From: Paul Cann <Paul.Cann@arun.gov.uk>
Sent: 27 September 2021 11:51
To: Planning.Responses <Planning.Responses@arun.gov.uk>
Subject: RE: Planning Consultation on: AB/112/21/DOC

Engineers comments on surface water drainage (Conditions 4 & 5);

Application No: AB/112/21/DOC
Registered: 26th August 2021
Site Address: 1-7 Canada Road Arundel BN18 9HZ

Description of Works: Approval of details reserved by condition imposed under AB/4/18/PL relating to conditions 4-surface water drainage, 5-maintenance & management of surface water drainage & 7-Construction Management Plan.

HIGHWAY RETAINING WALL  
HOLLOW BLOCK WALL

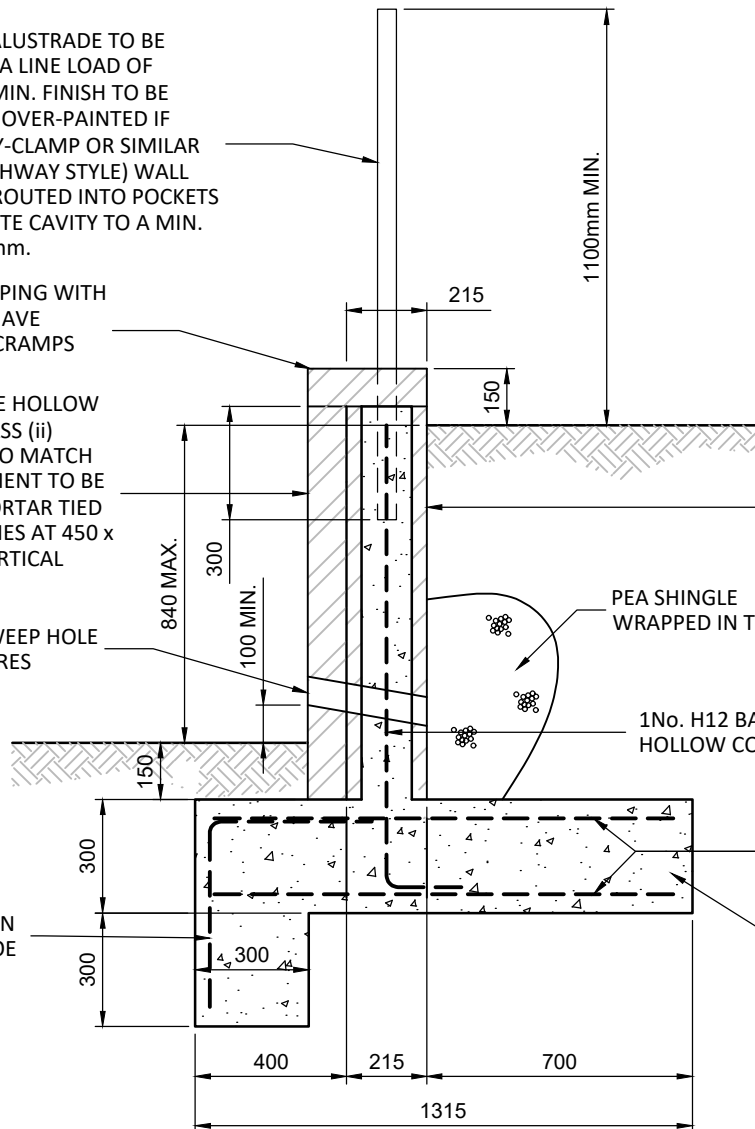
3. Highway retaining walls noted to include weepholes/granular backfill – please update note on plan.
4. Indicate historic surface water drainage on site including its proposed abandonment.

TYPICAL ACCESS CHAMBER DETAIL - TYPE 3
(Scale 1:20)

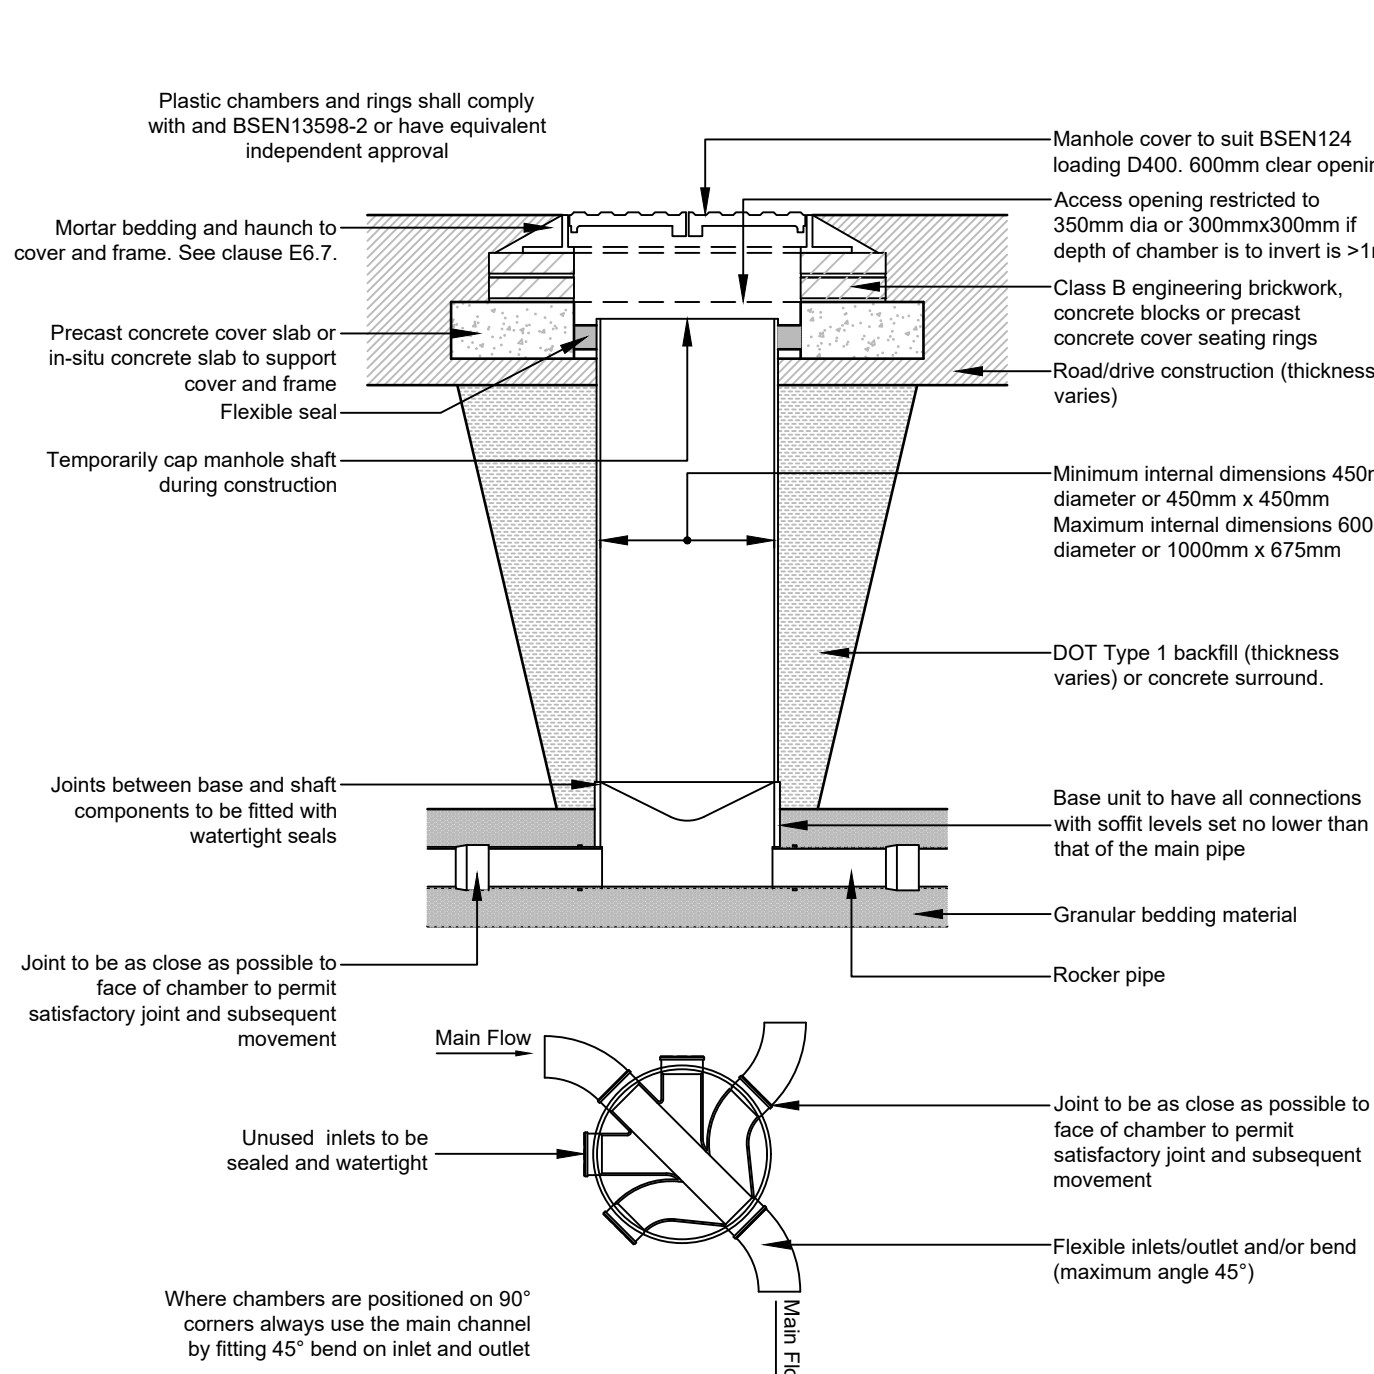
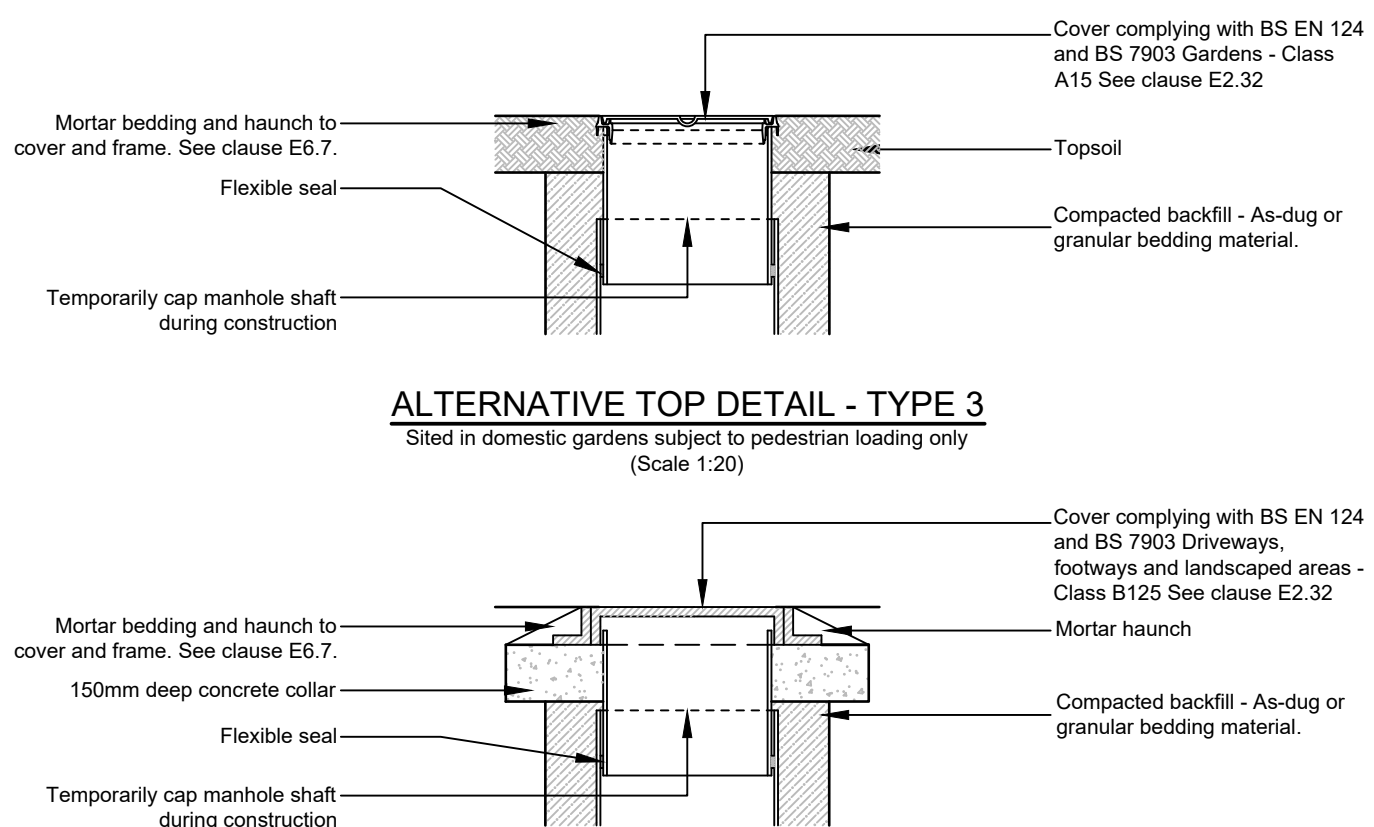
8. The proposed new road gully associated with the Section 278 works will also require Section 106 approval from Southern Water – add note to plan. The existing note relating to the other surface water connection is headed ‘foul sewer connection’ in error – please adjust.
9. Construction details;
 - a) Include sump outlet detail for channel drain.
 - b) Catchpits – specify ductile iron covers & frames of suitable load grading.
 - c) Provide control chamber detail.
